Incorrectly quoted widths/encroachment/negative impact on amenity

Plan showing Potential Road Widening, indicates the intention to piggyback proposals for access to a second development potentially leading to 400%-500% increase in residential traffic on Bierley Marsh.

Title number **WYK813938**
Ordnance Survey map reference **SE1929SE**
Scale **1:1250 enlarged from 1:2500**
Administrative area **West Yorkshire :**
Kirklees

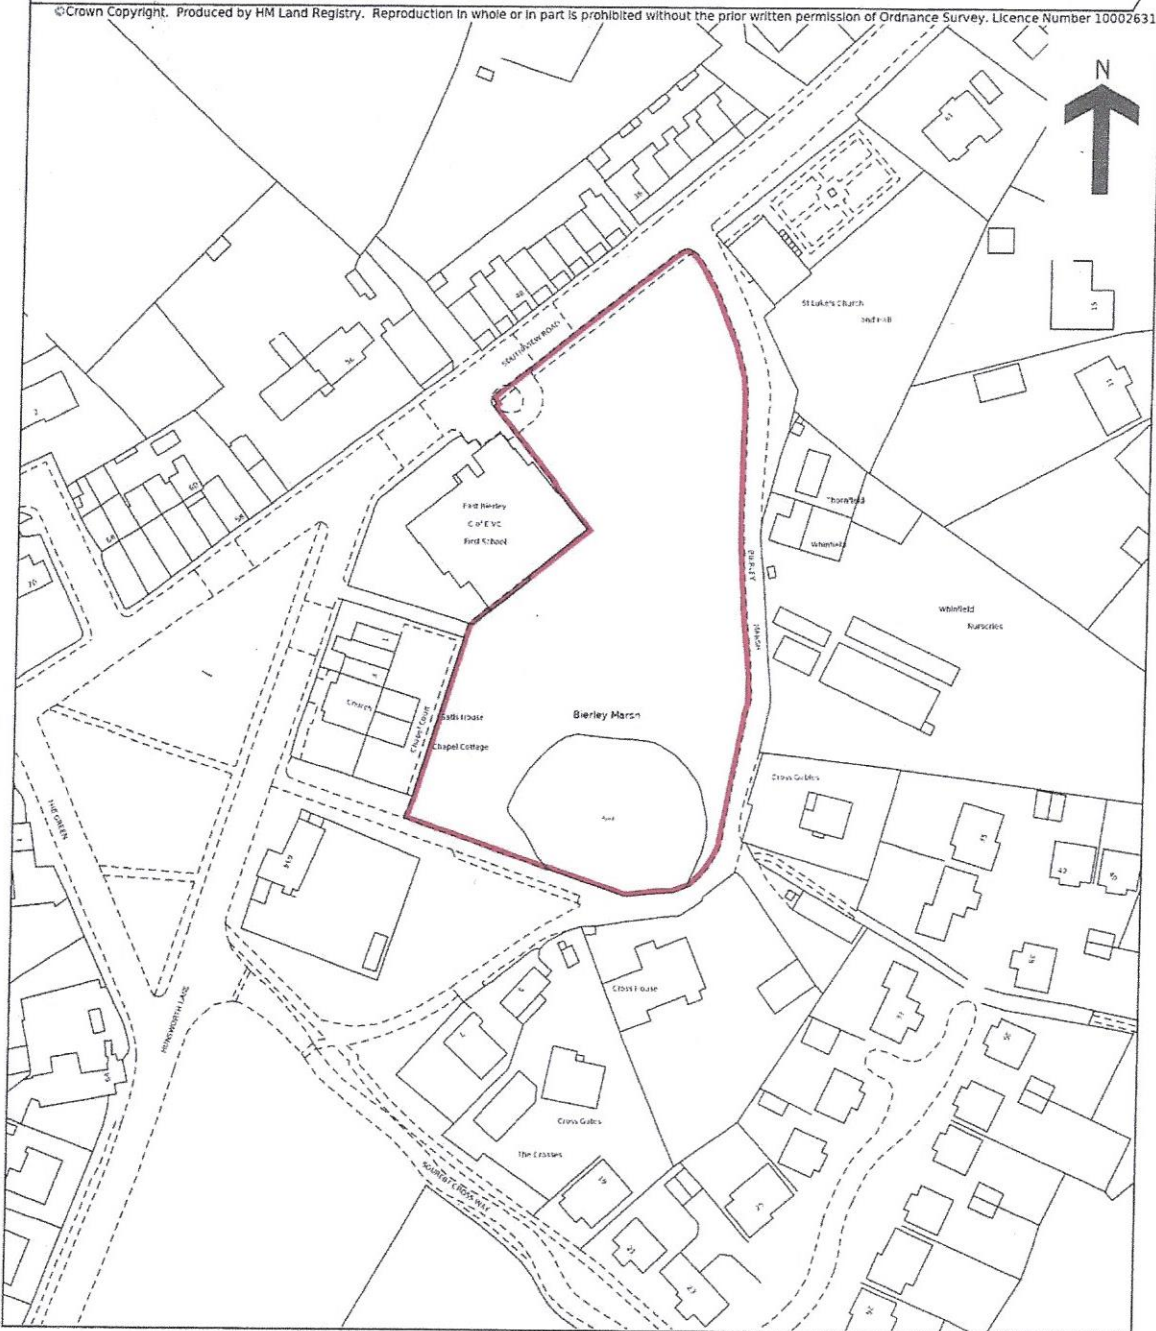
The Land Registry title plan WYK813938, shows the area of Common Land (CL222) Kirklees own and the associated legal and physical boundaries. Title plan, based on mapping at the time, shows boundaries, including verges and records Bierley Marsh as a single track little over 3m wide. Images below confirm this. More recent changes, repairs to Common Land and Kirklees tarmacking work, has created the impression of wider layout.

Drawing
**SECTION 38
COLOUR LAYOUT**

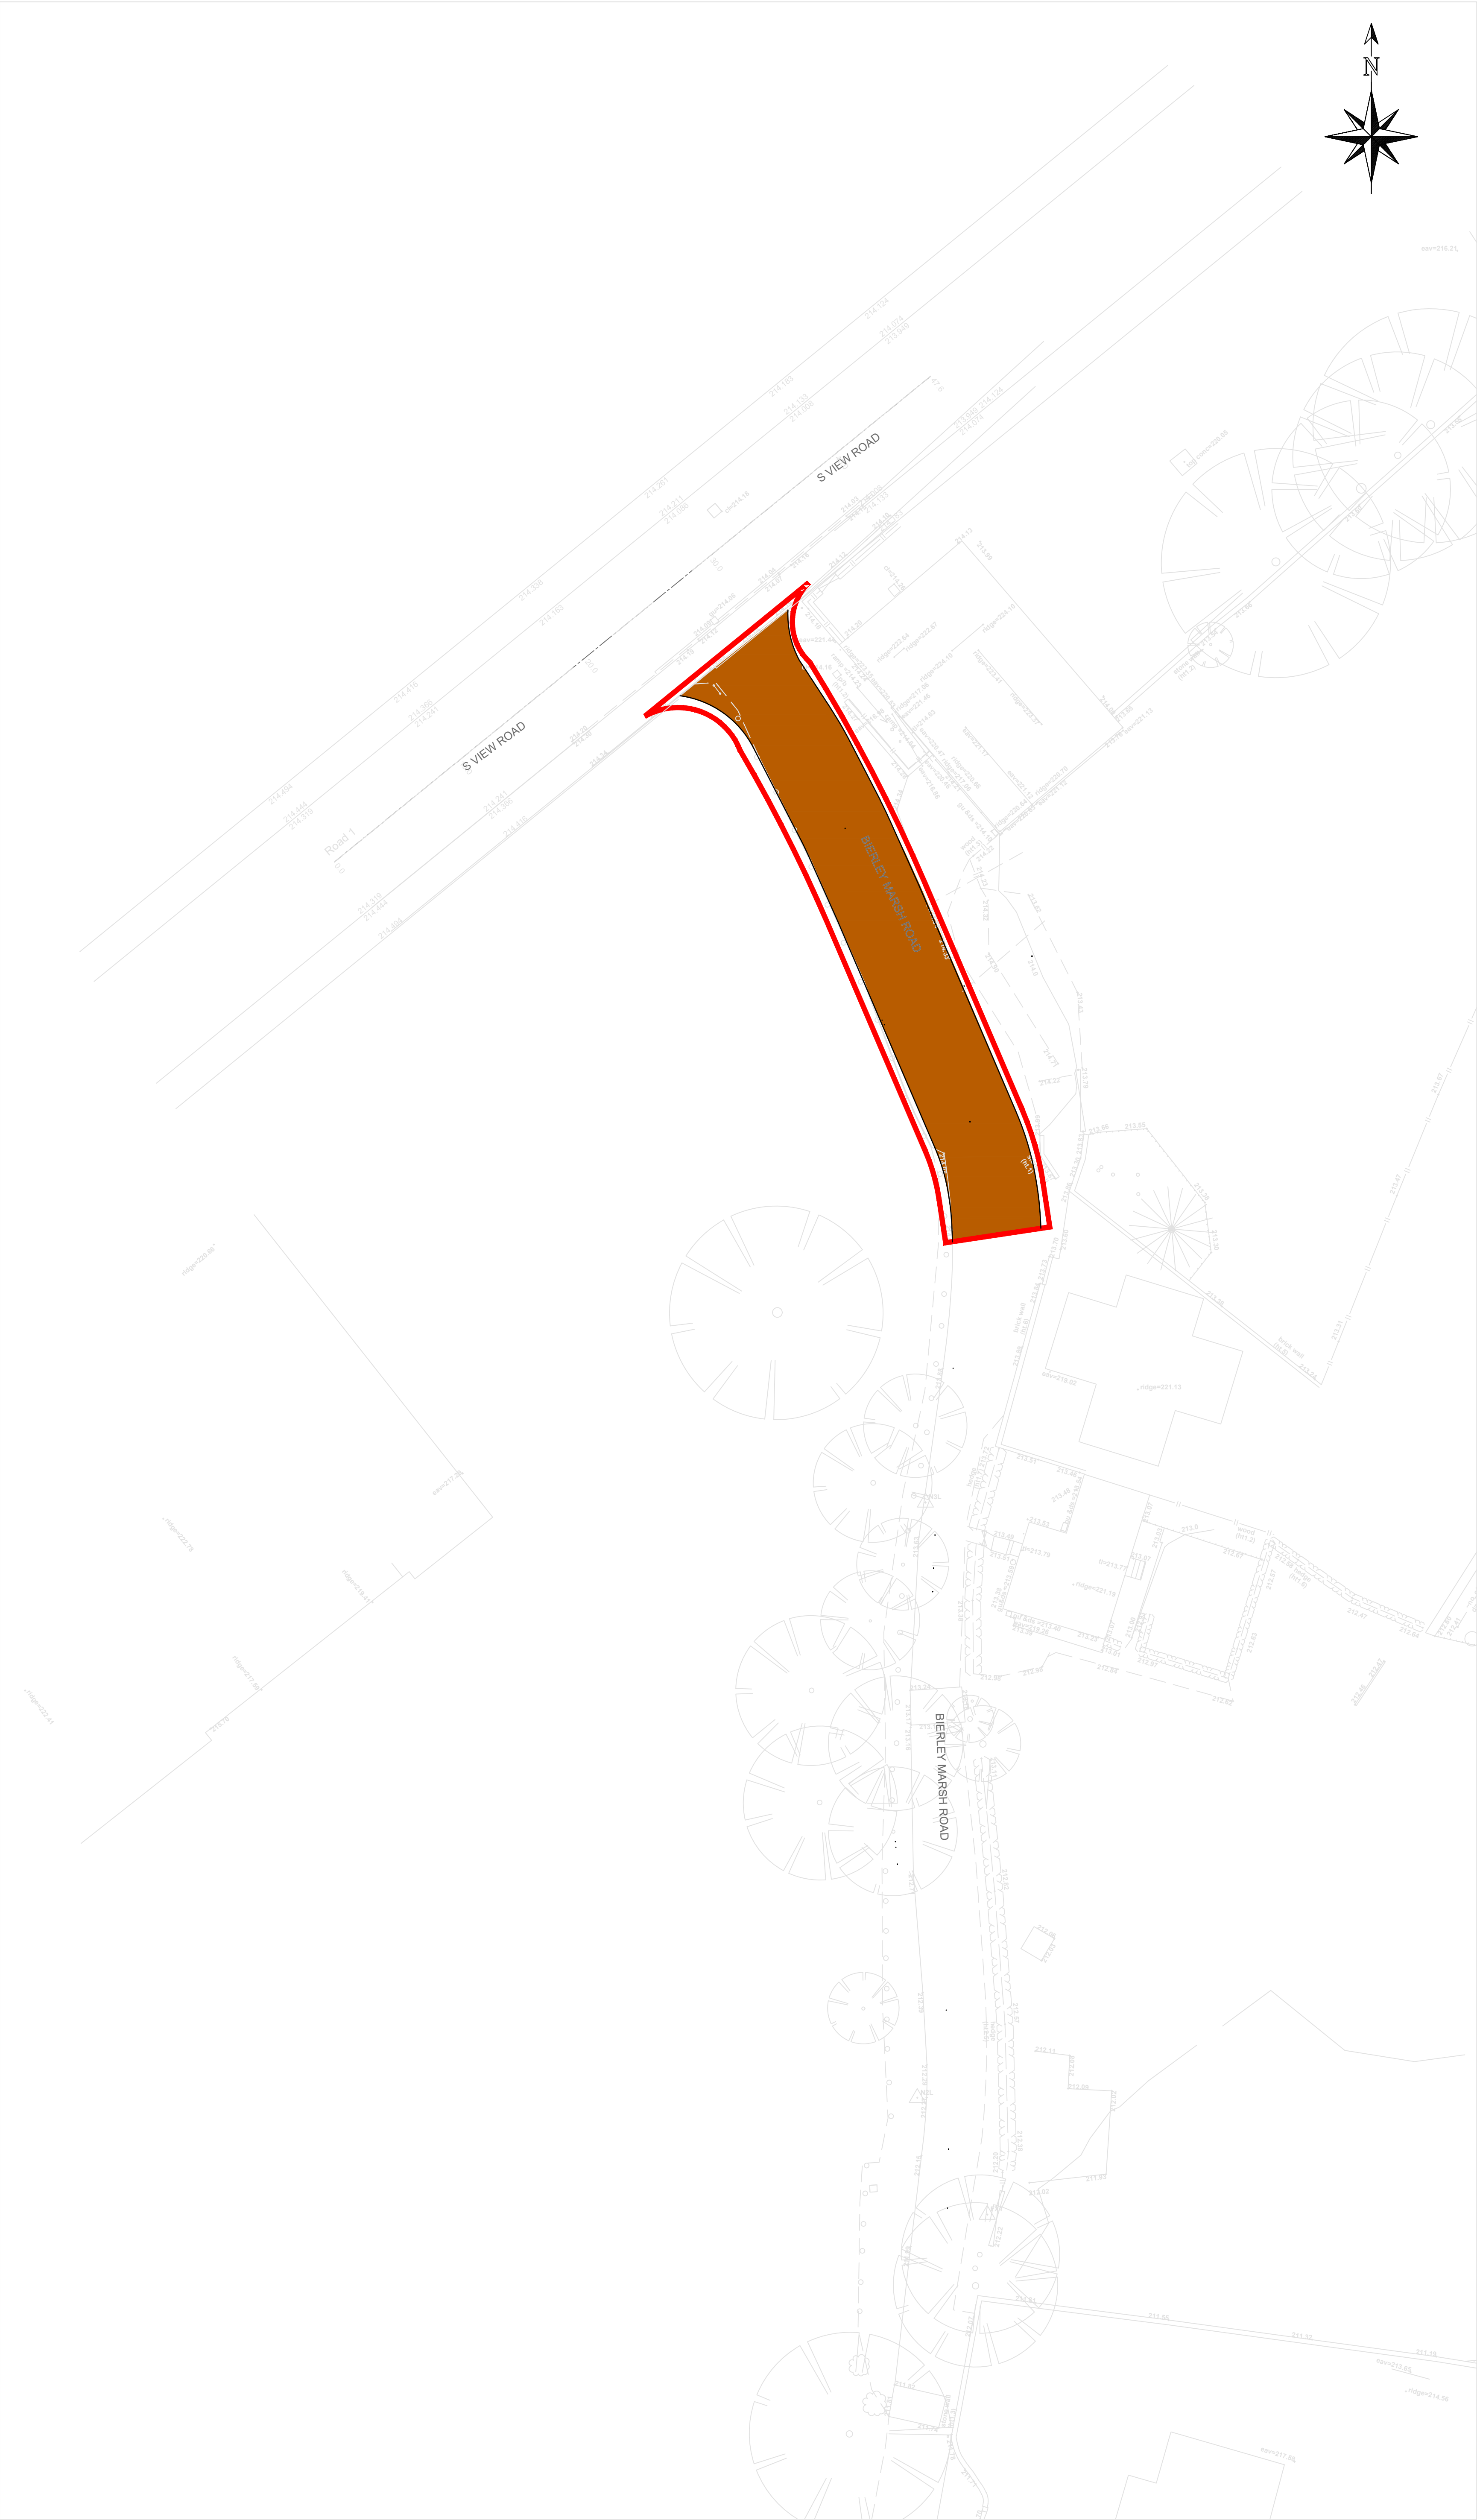
Kirklees confirmed Bierley Marsh to be a Private Street (letter 19:06:91). It is essentially a single track with legally recorded public rights of way; Public Footpaths (SPE/6/20 & SPE/6/30) quoted in Kirklees Definitive Plan as no more than 10ft wide.

Road works will affect SPE6/20 from Cross Gables to South View Road, over which 4 properties have vehicular access rights.

Proposals are unclear about road Adoption.

As a Private Street, fronting properties are responsible for maintenance up to centreline. Associated risk is offset by benefits of less traffic and noise. Proposals will clearly worsen risk but negate benefits and impact Footpath safety and utility. Ad Medium Filum rights apply to this land including verges.

Current owners of Thornfield upgraded fronting rough/soil verge in early 90's to provide improved access and parking. Kirklees subsequently tarmacked over the upgraded verge, therefore losing definition. Proposals appears to be removing accrued rights for parking, including this verge in quoted road widths but retaining/incorporating continuing verge in proposals. Kirklees have commented previously *"I would not envisage any change in circumstance with regards to your parking rights"*.

Quoted widths are to bollards placed within Common Land, as repair work done by East Bierley Preservation Society (EBVPS), including placing compacted loose stone. Kirklees have confirmed that the road proposal, as previous submission 2020/90996, encroached up to 2.5m on Common Land, which is protected land under the Commons Act 2006. This proposal does the same, as images below clearly show:
